TOWN AND COUNTRY PLANNING ACT 1990

Reference: H23-0733-22 **Date of Decision:** 16th September 2022
Applicant: Mr D S Rous
Irby House
Millgate
Whaplode
Spalding
PE12 6RT
Location: Rear Of Irby House Millgate Whaplode Spalding
Description: Change of use of grassland to paddocks for grazing and erection of stables -
part retrospective

Job Ref.	Drawing No.
4015-19.	01

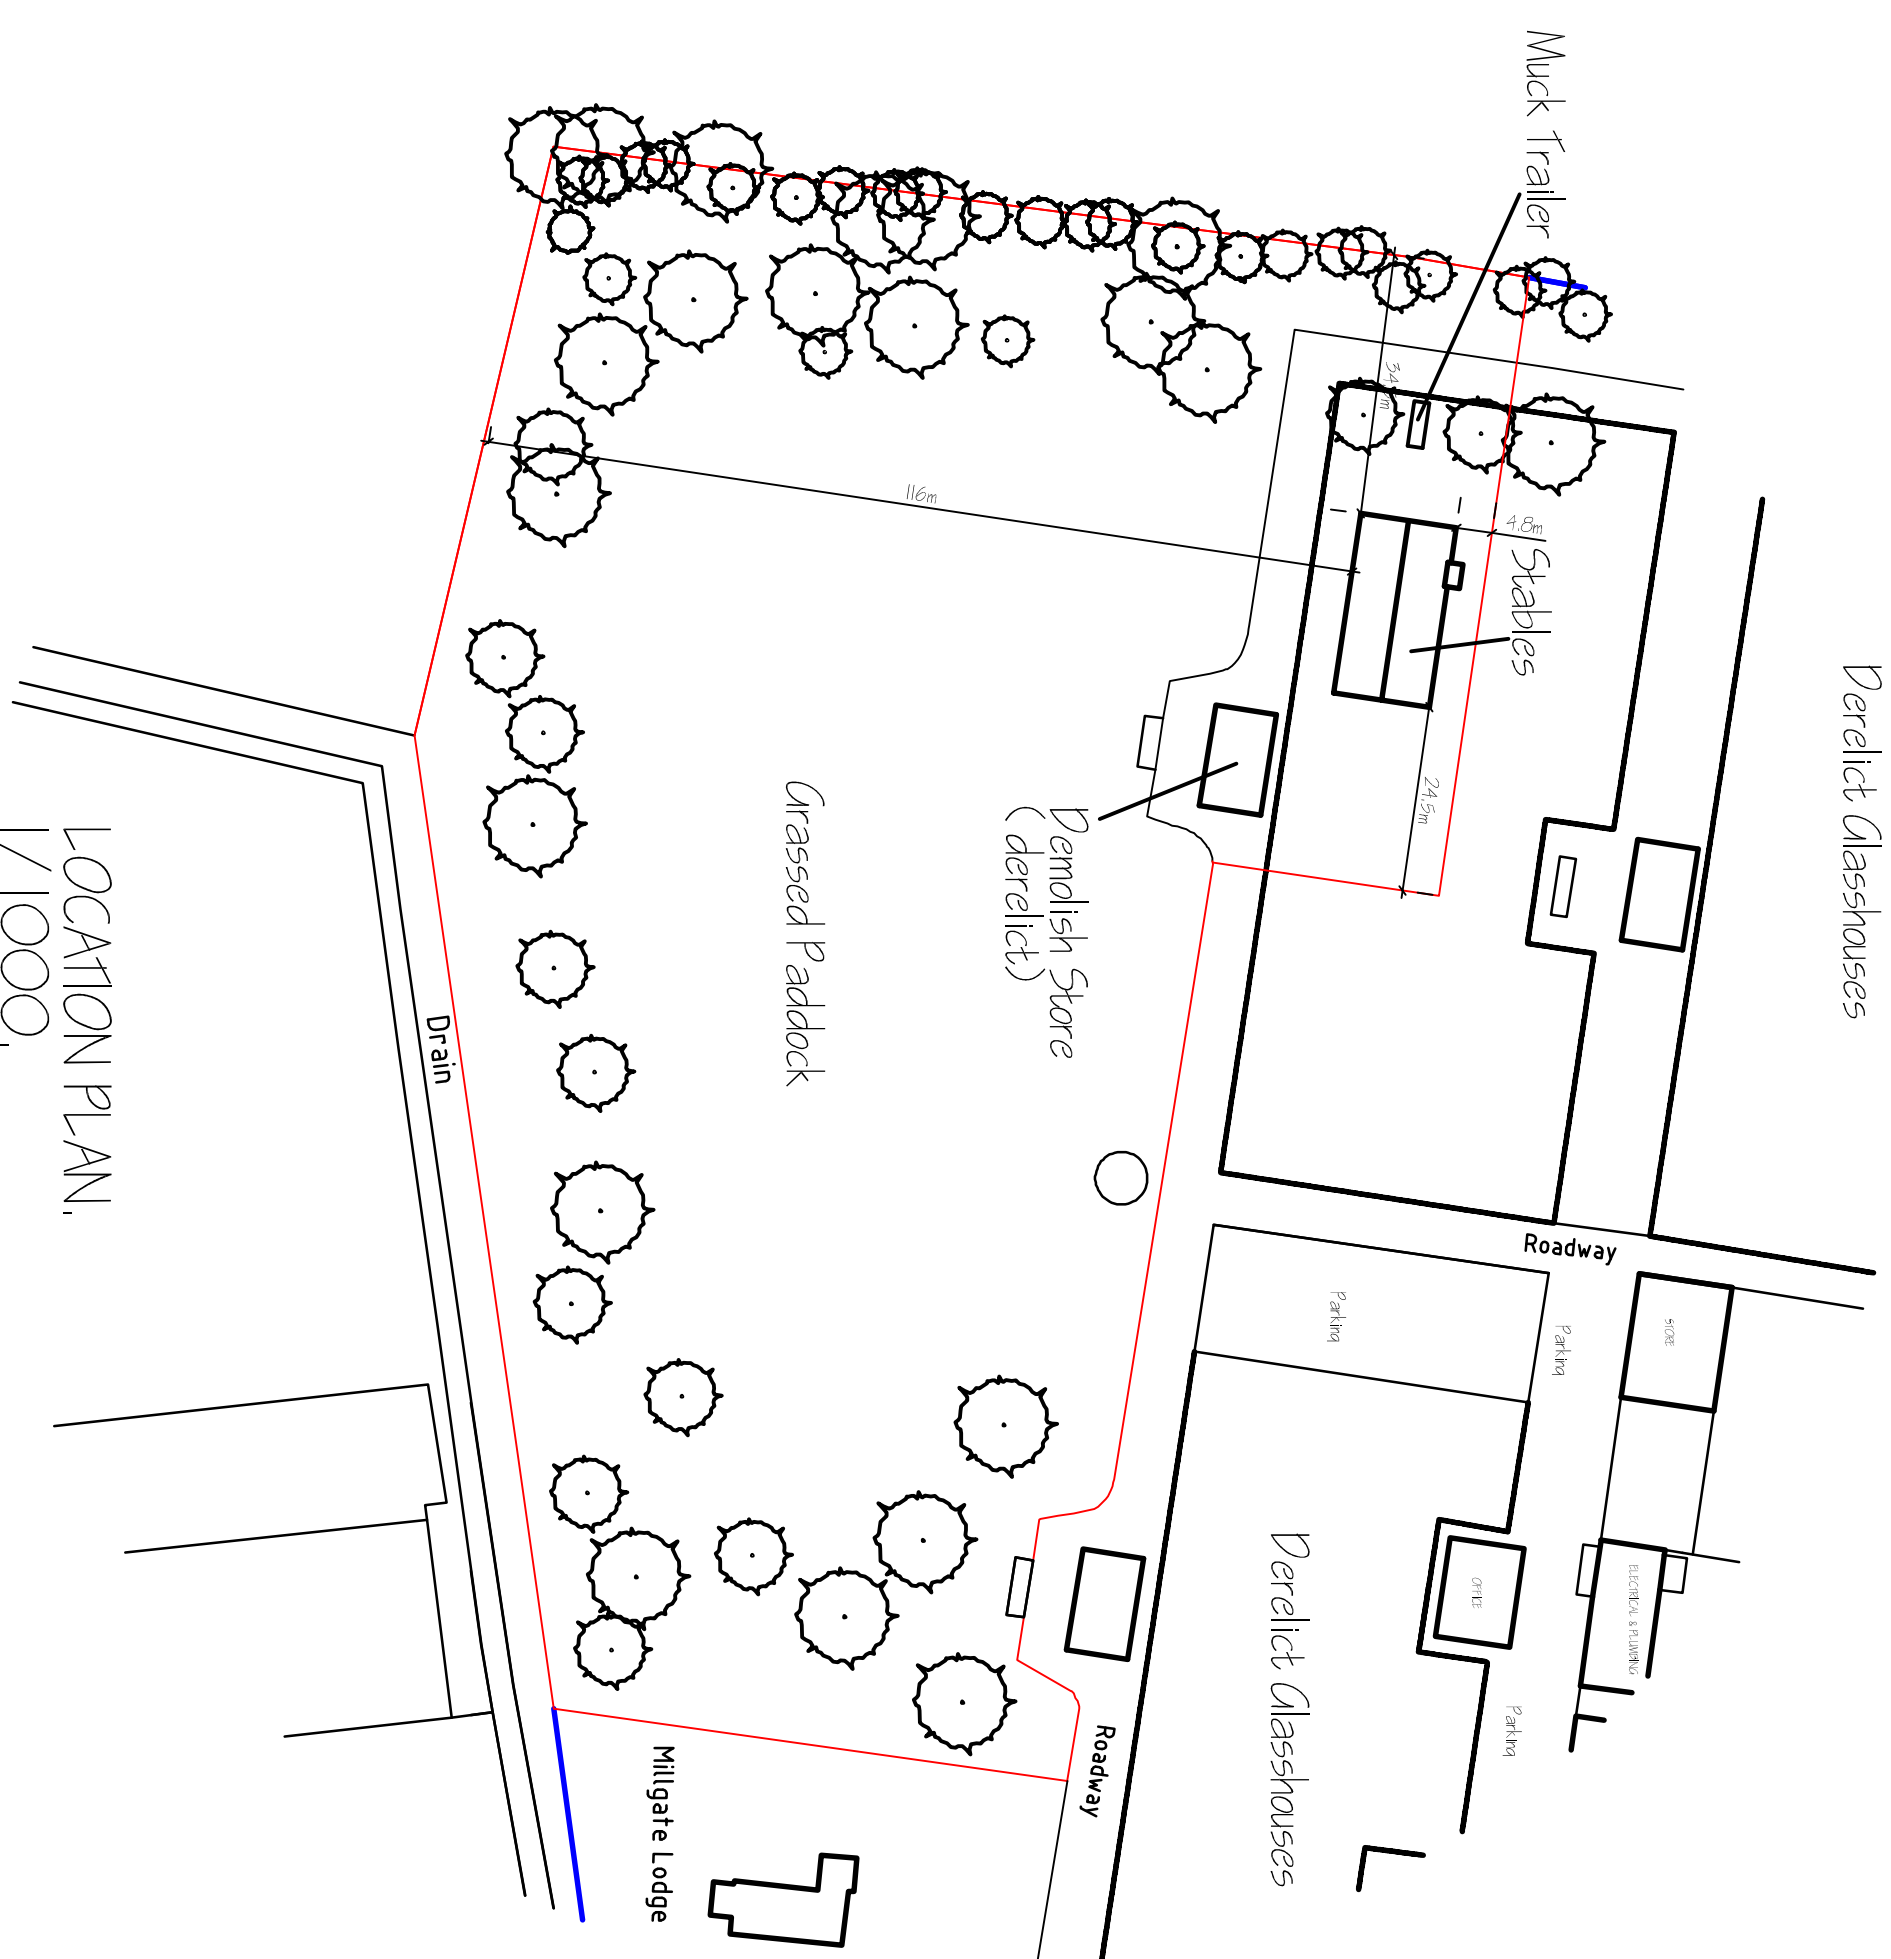
- 3 Waste bedding and manure from the stables shall be stored in a trailer positioned within 10 metres of the store (former boiler house) shown on dwg. no. 4015-19 01 and not in the position indicated. It shall thereafter be disposed of in accordance with details within the justification statement. There shall be no burning of bedding or manure upon the site.
